Sign Plan_V1.pdf Markup Summary

American Dog Pros Sign Plan

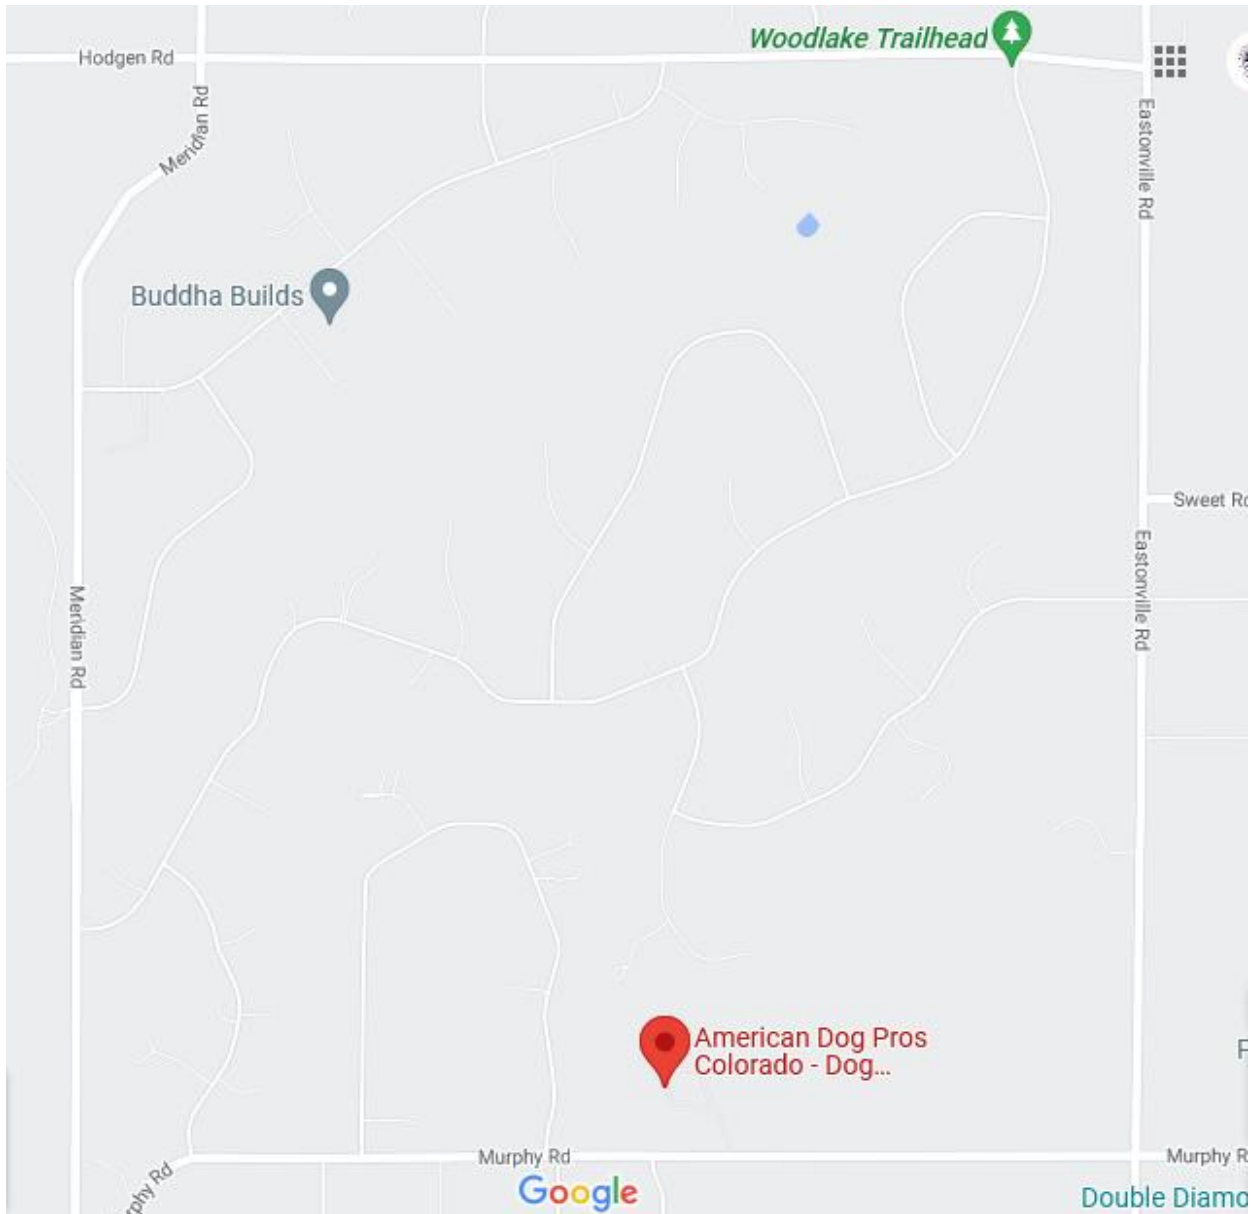
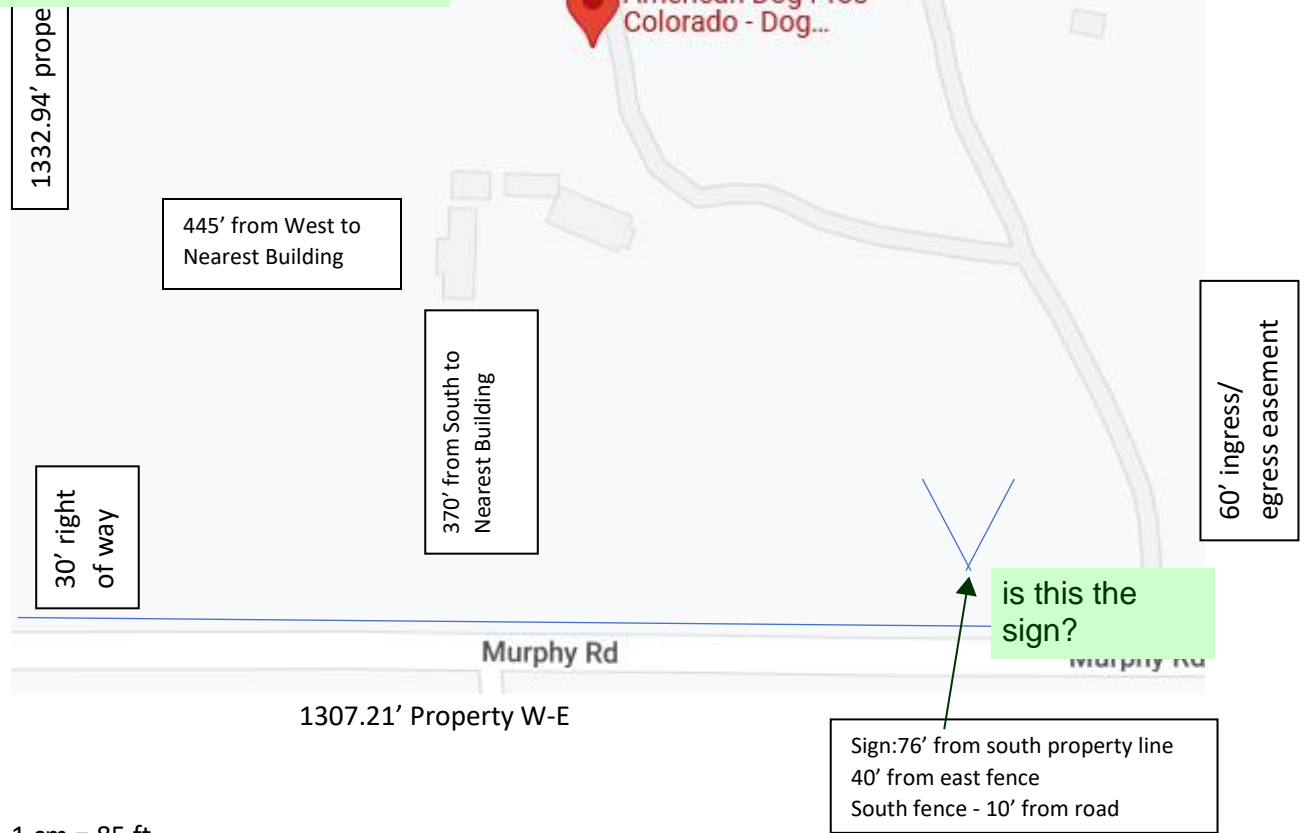
Please show sign setback distance to the property line (as opposed to the road).

Please show location on site development plan.

Please cite distance from the southern property line.

Is this the sign copy?

Is this referring to the distance from the western property line?

Is this referring to the distance from the southern property line?
